From: Anna Appleton
Sent: 08 November 2018 16:34
To: Simon Davis
Cc: Planning.Responses
Subject: RE: Planning Consultation on: BR/263/18/PL

APPLICATION **BR/263/18/PL**

Site Address: St Josephs Albert Road Bognor Regis PO21 1NJ

Description of Works: Application for variation of conditions following grant of planning permission BR/348/16/PL relating to Cond 2 - Block plan & smoking shelter, Cond 9 - smoking shelter materials & Cond 11 - use of smoking shelter & conservatory.

CLIENT Butlins Skyline Ltd.
PROJECT St Josephs
DRAWING TITLE Smoking Shelter

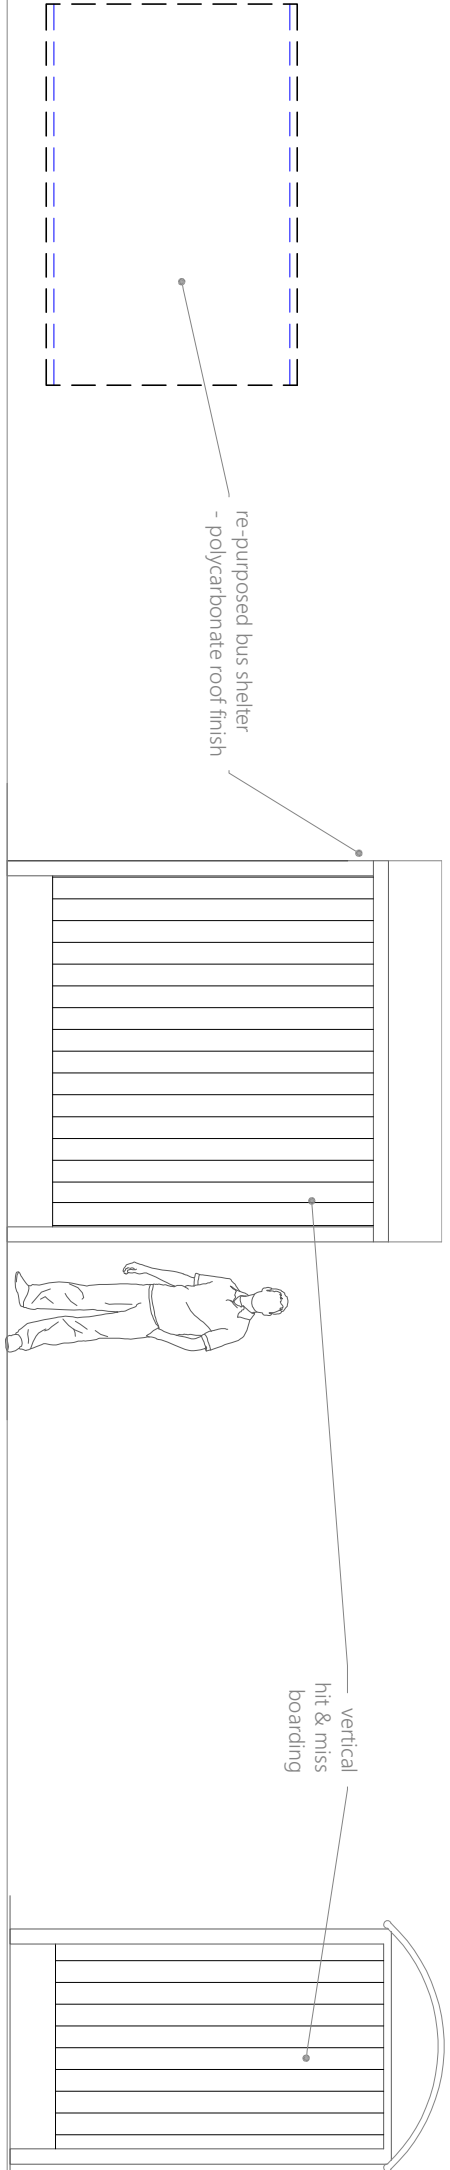
I can confirm that Environmental Health have no objection to the intended increase in the size and location of the smoking shelter provided the time restrictions are still applied (no use between 22.00 and 07.00). I would also request that the western side of the shelter which faces towards the rear of Las Arenas is made of solid construction to reduce noise break out. When constructing the shelter the applicants should note that at least 50% of the shelter construction should be open, so with a roof there should only be one other wall. The other conditions in relation to the shelter should remain.
